From: [Redacted]
Sent: 25 June 2021 14:30
To: 'Amy Myer' <Amy.Myer@arun.gov.uk>; Laura Gibbons <Laura.Gibbons@arun.gov.uk>
Subject: Y/80/21/DOC

Following the engineers comments my engineers has replied and attached revised stuff

In response to the drainage engineer's comments;

Infiltration testing at shallow depths carried out on 30th and 31st January 2018.

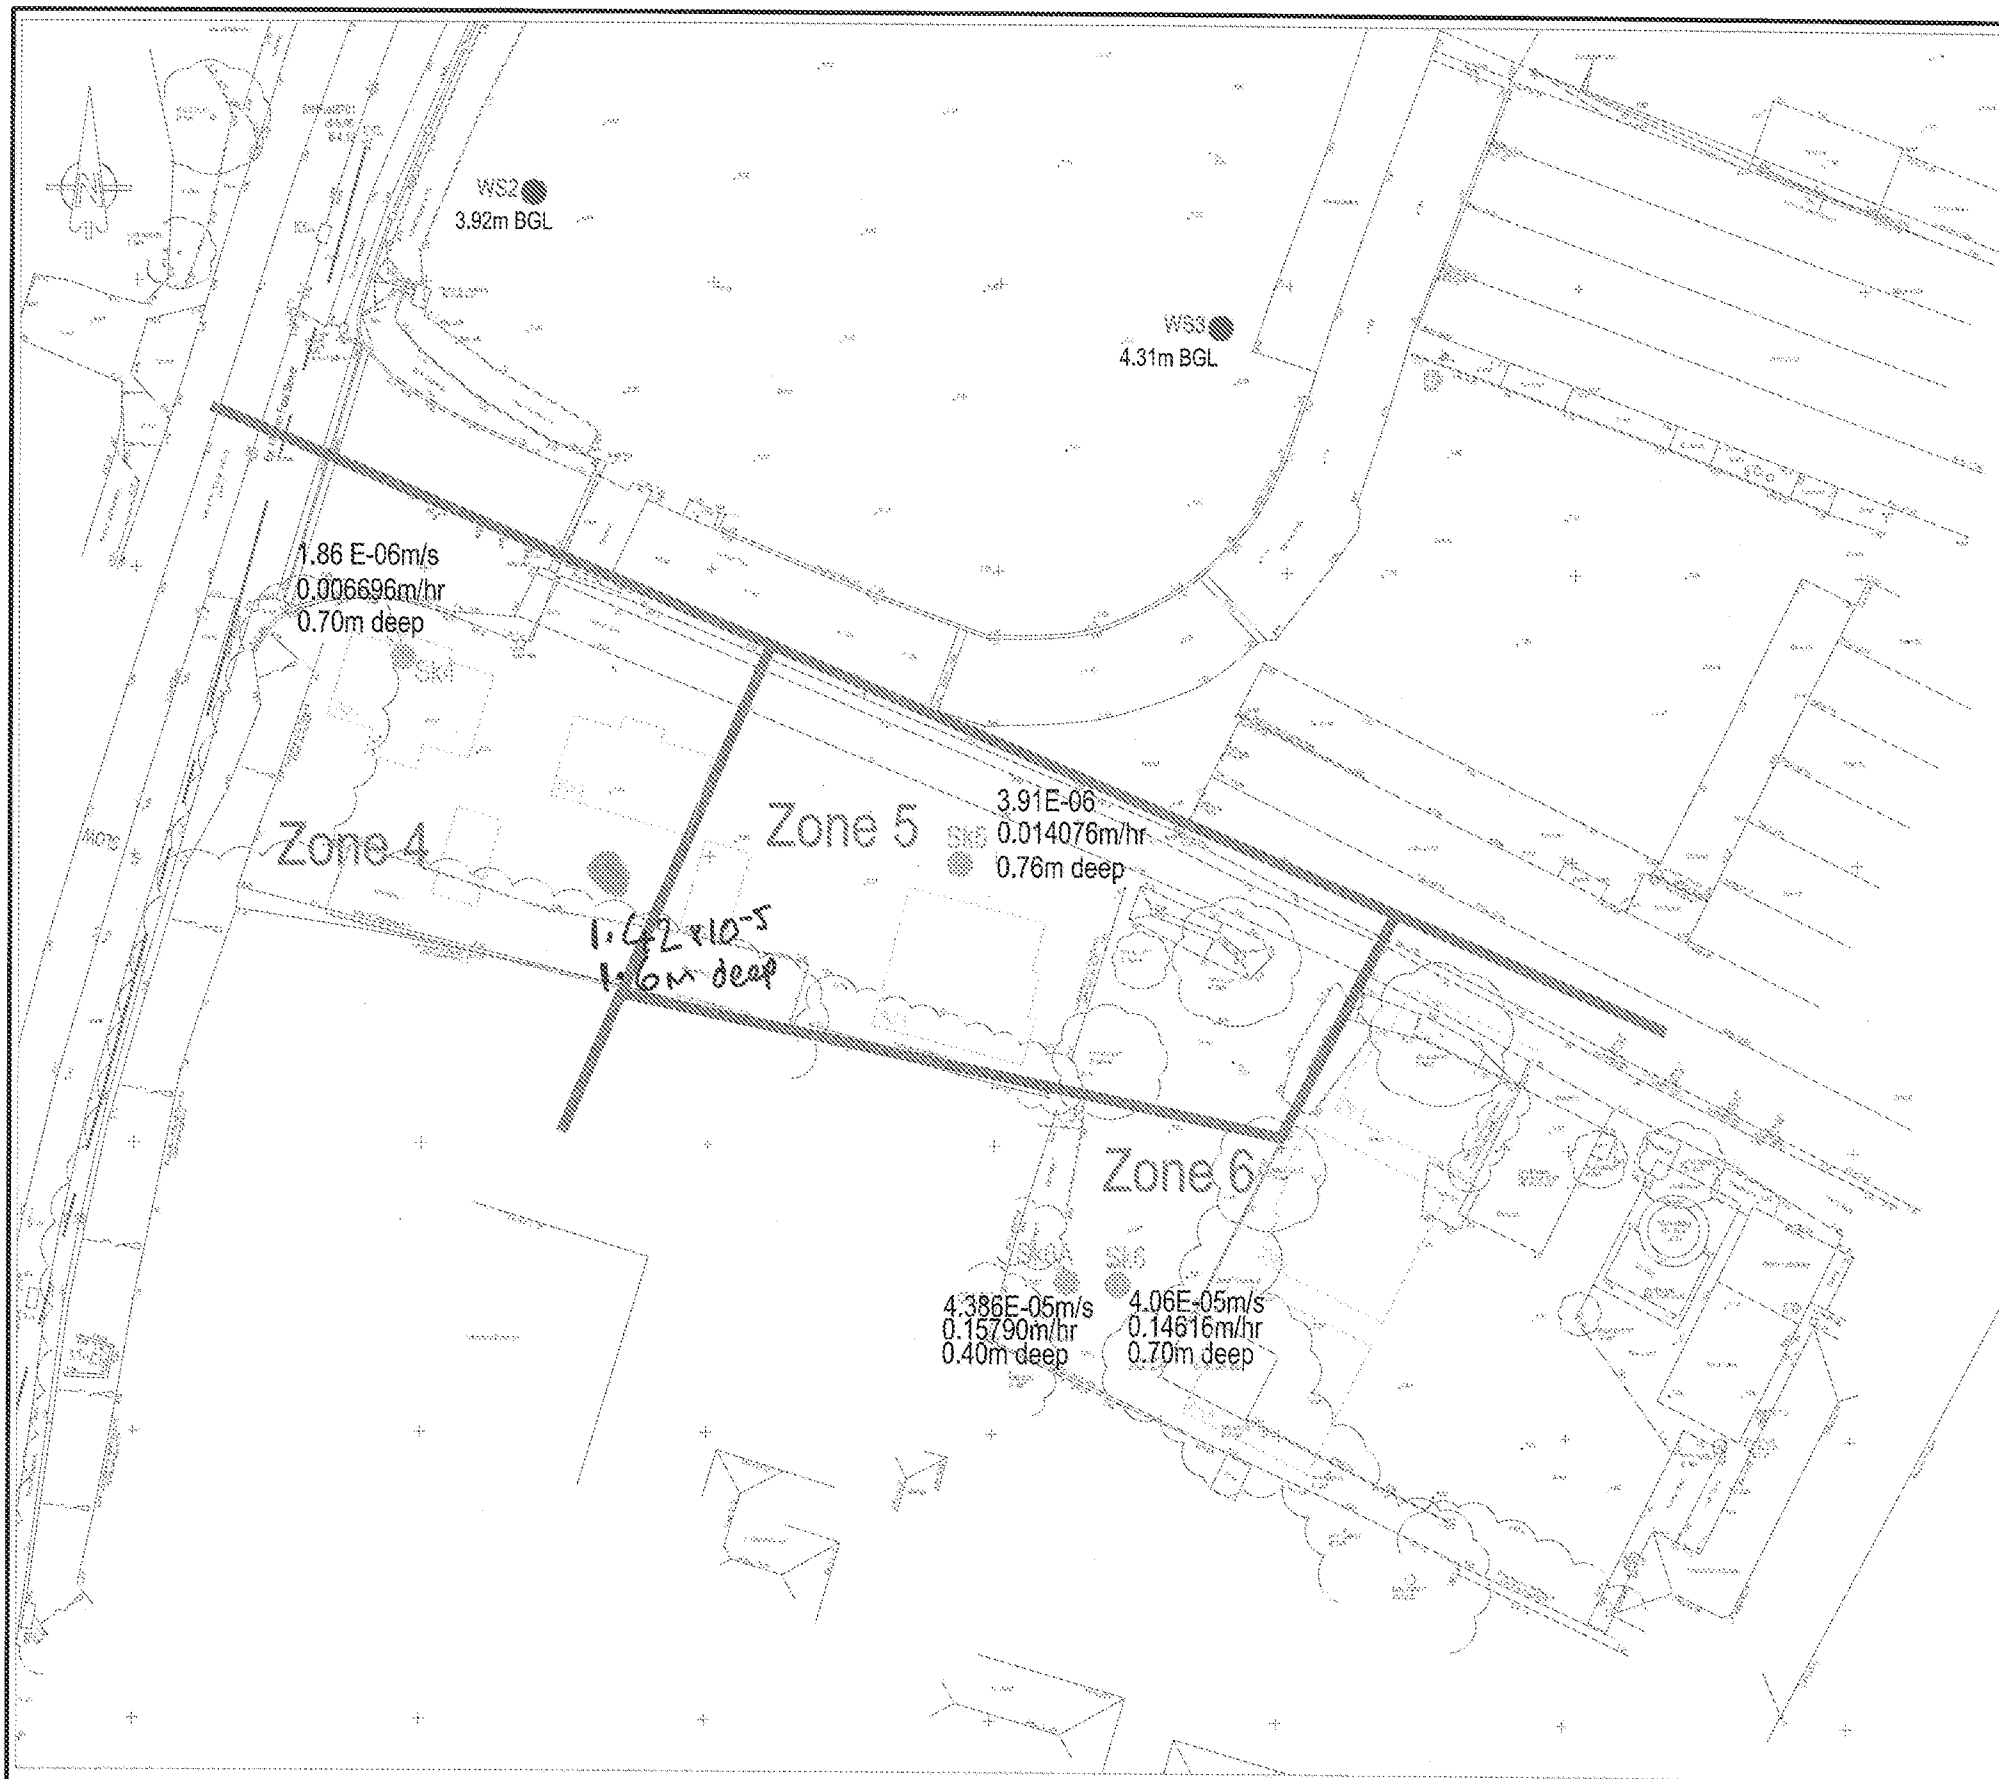
1. I have noted infiltration testing date / locations on the plan and attached to the calculations.
2. I have applied the shallower depth infiltration testing results to the permeable paving design and updated the calculations / drawings. Sub base depth increased to 400mm.
3. Drawings updated (and attached) with permeable paving finish and formation levels.
